Deviation Request_v2 redlines.pdf Markup Summary 3-7-2022

EL PASO COUNTY, CO  
MAIN ST. AND SECURITY BLVD.  
ACCESS EXHIBIT

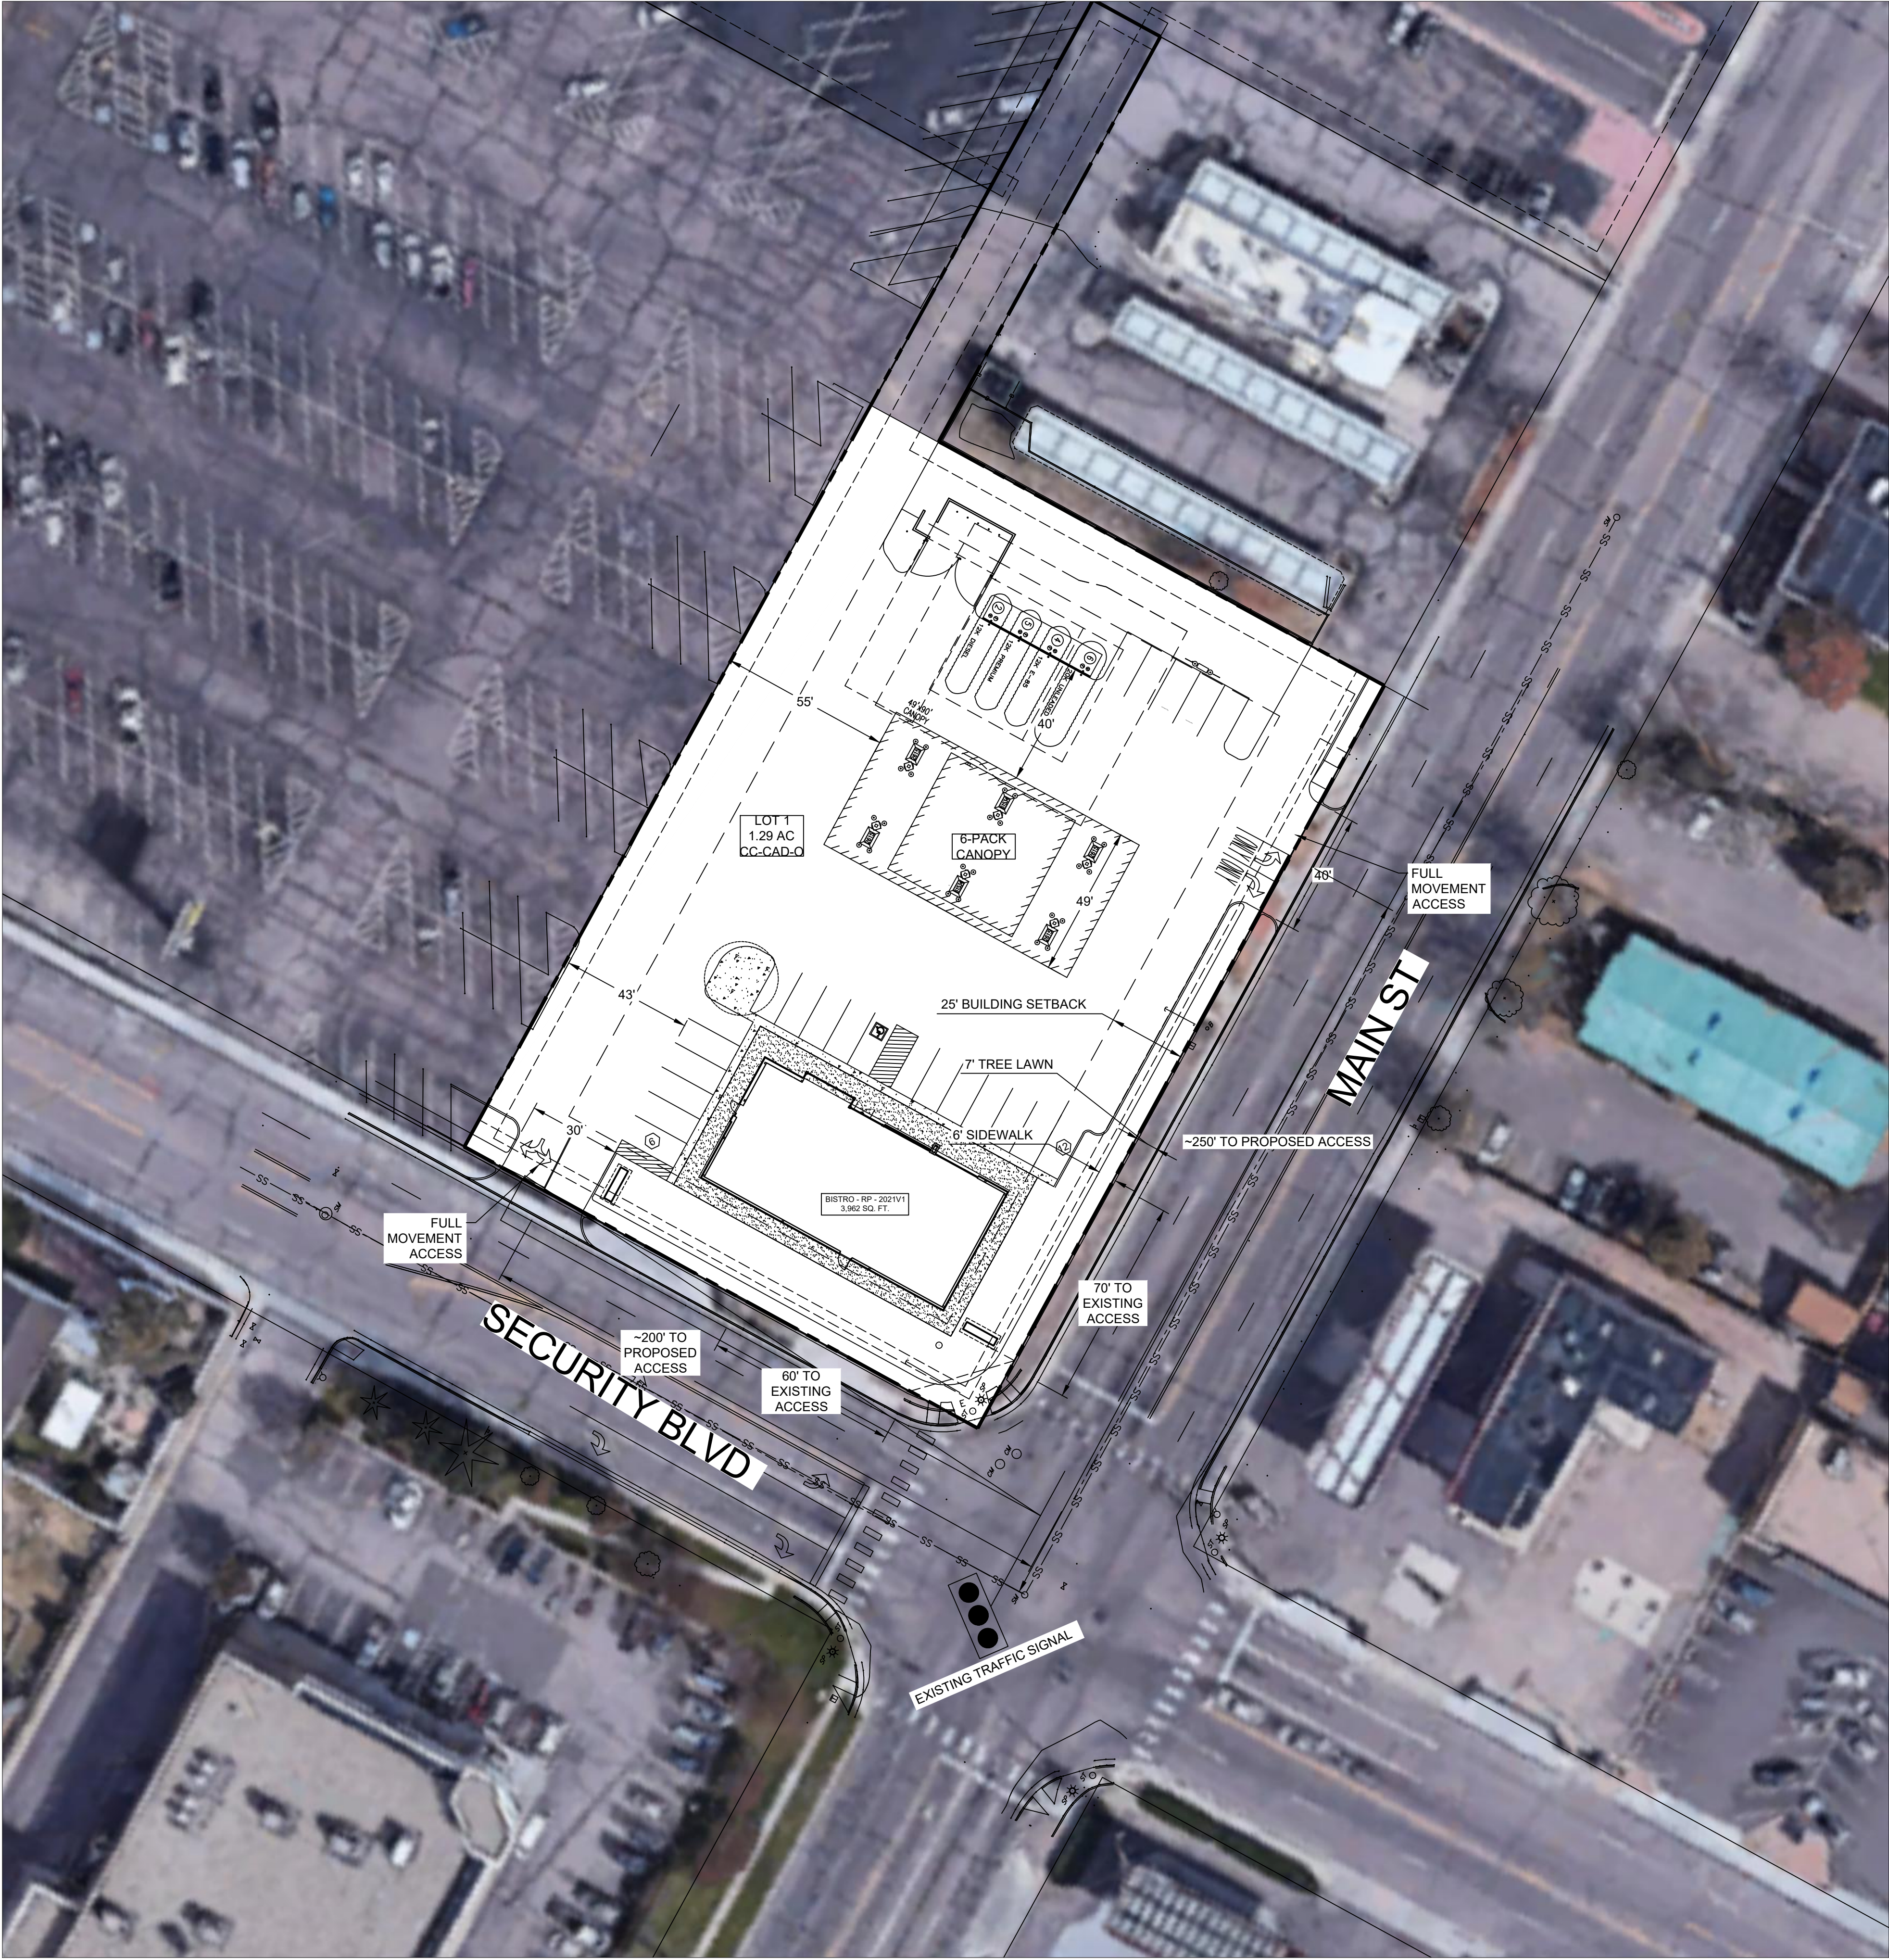
Per the comments made in the previous review, full access movements will not be allowed at either access point. Only right-in right-out movements will be allowed. Please revise all documents (deviation and TIS) to consistently analyze and request these movements.

Please note, there are platted common access easements for the two subdivisions to the north and to the west under plat numbers 11642 and 8989.

Unresolved. This is not a full movement access. Please call it out as a right-in right-out. Full movements will not be allowed onto either street.

Unresolved. This is not a full movement access. Please call it out as a right-in right-out.

EL PASO COUNTY, CO  
MAIN ST. AND SECURITY BLVD.  
SECURITY BLVD. ACCESS EXHIBIT

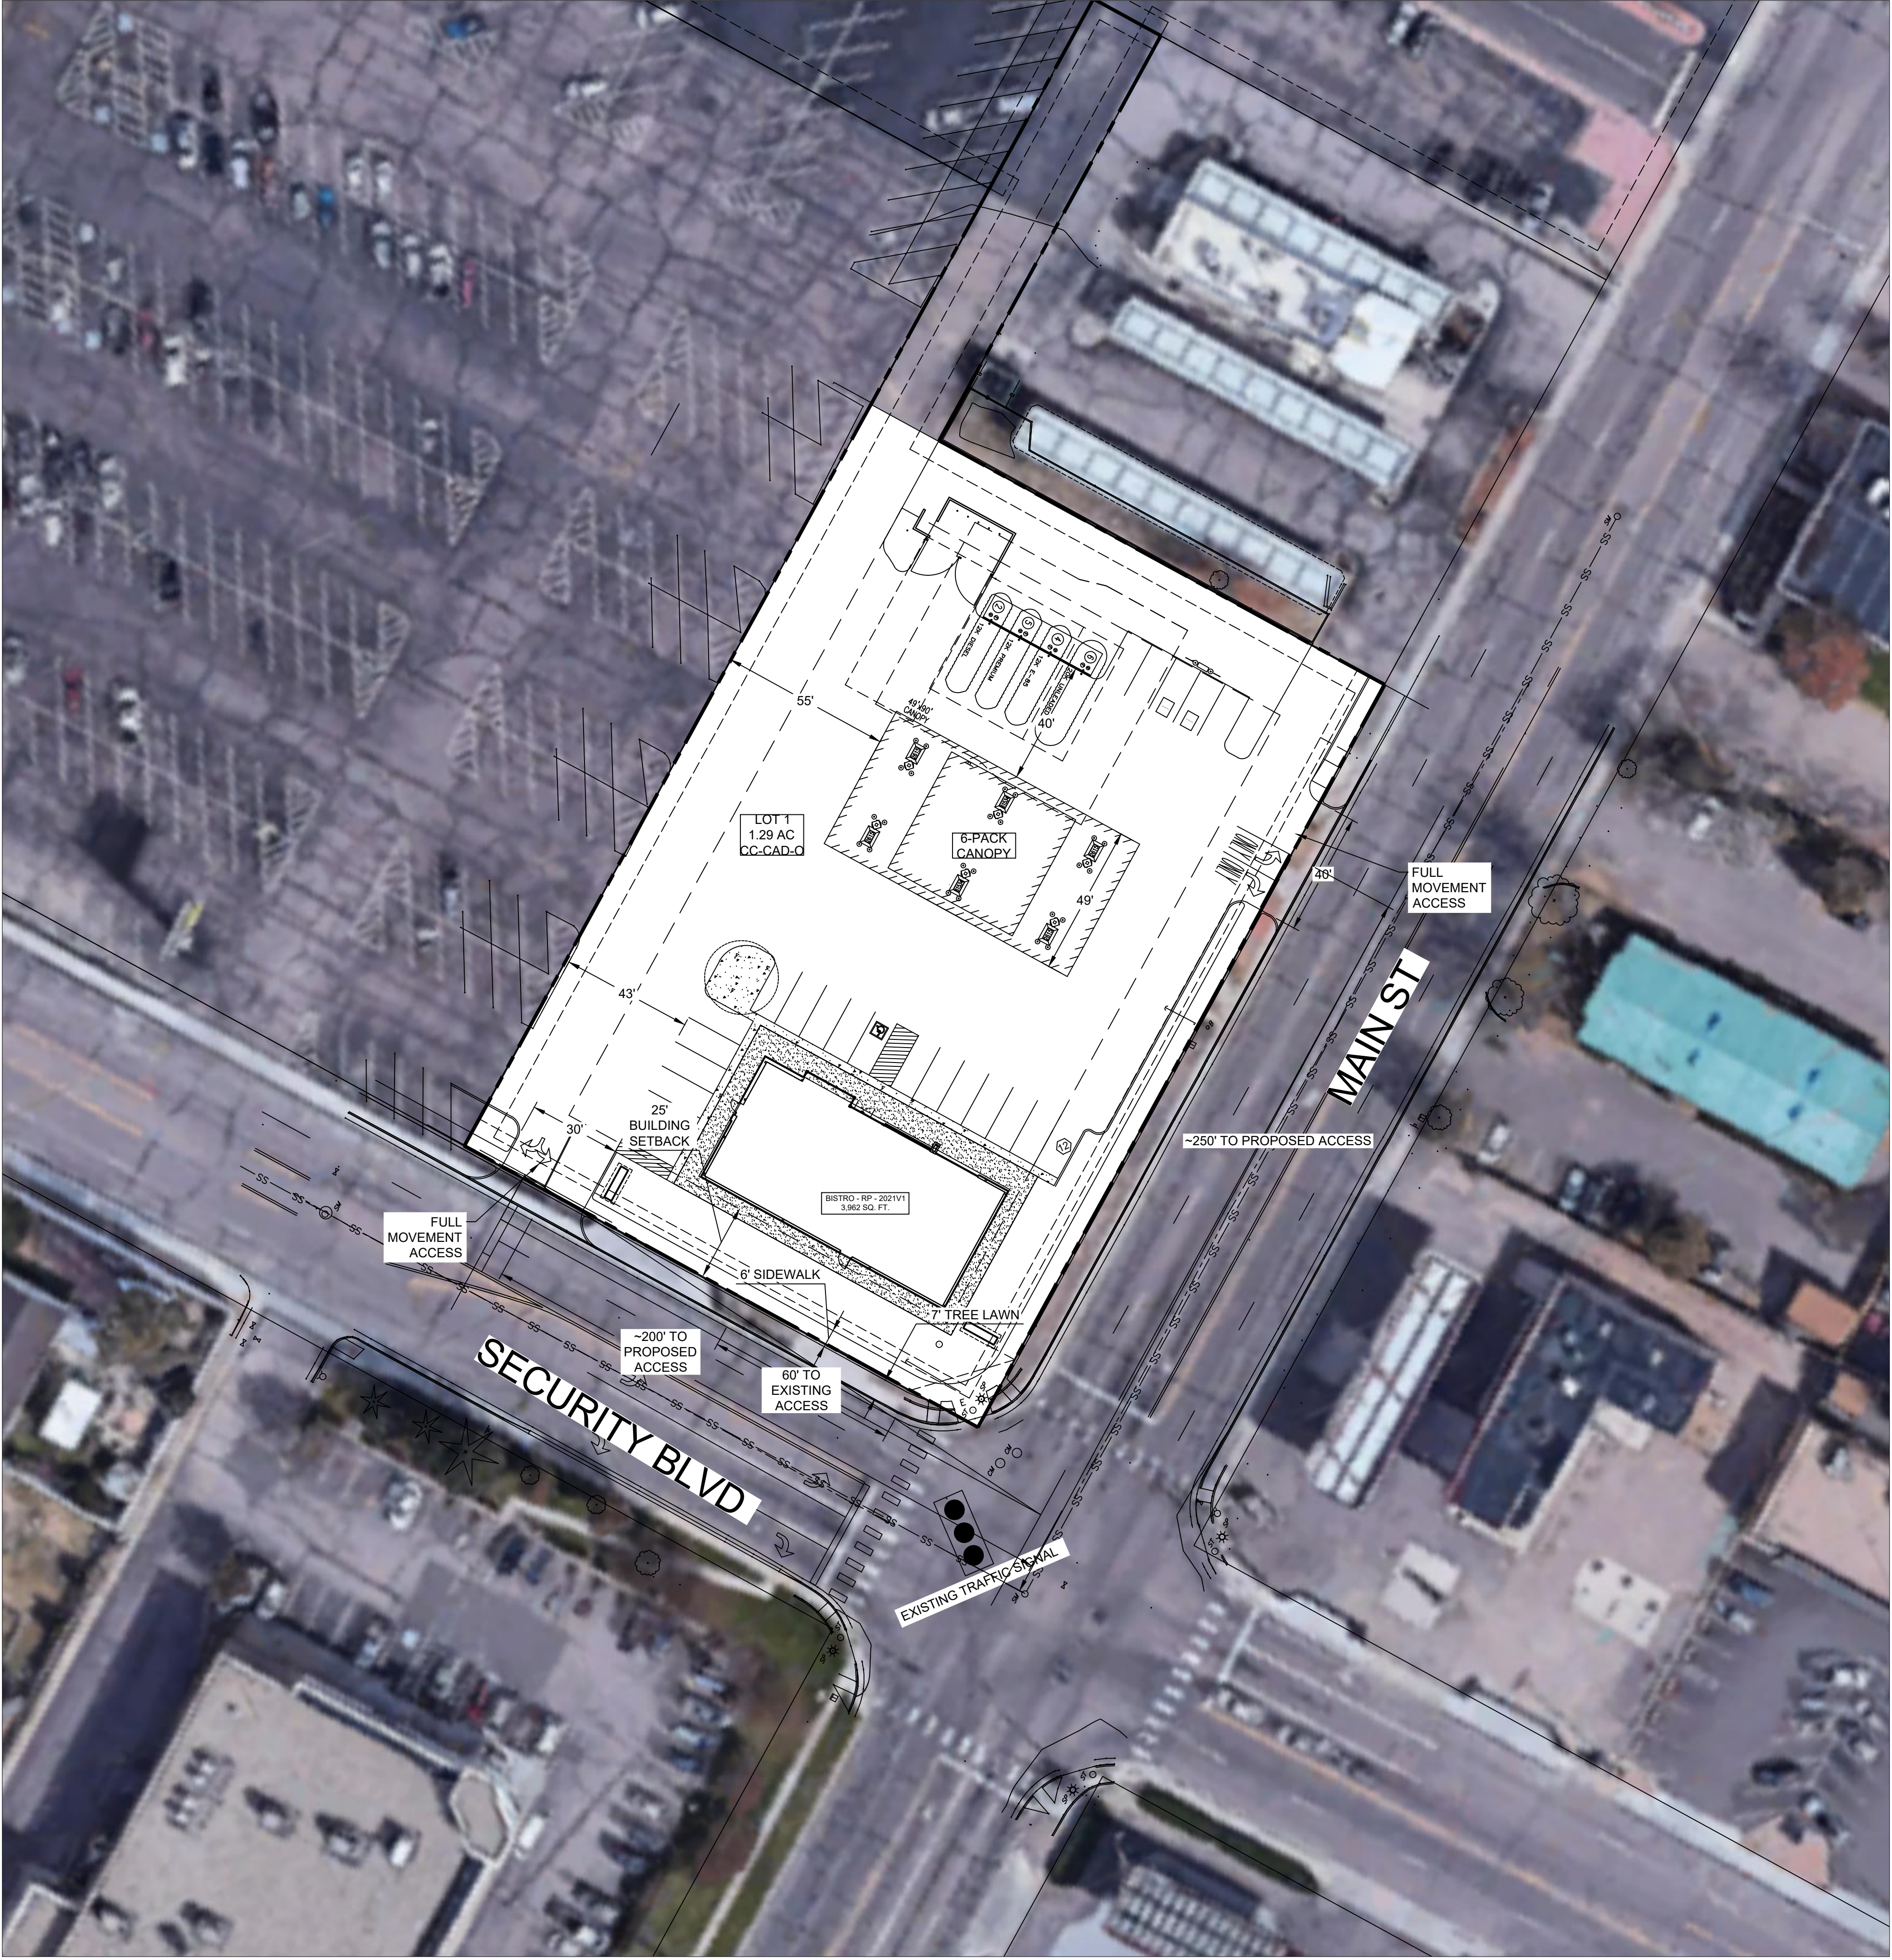
Please note, there are platted common access easements for the two subdivisions to the north and to the west under plat numbers 11642 and 8989.

Per the comments made in the previous review, full access movements will not be allowed at either access point. Only right-in right-out movements will be allowed. Please revise all documents (deviation and TIS) to consistently analyze and request these movements.
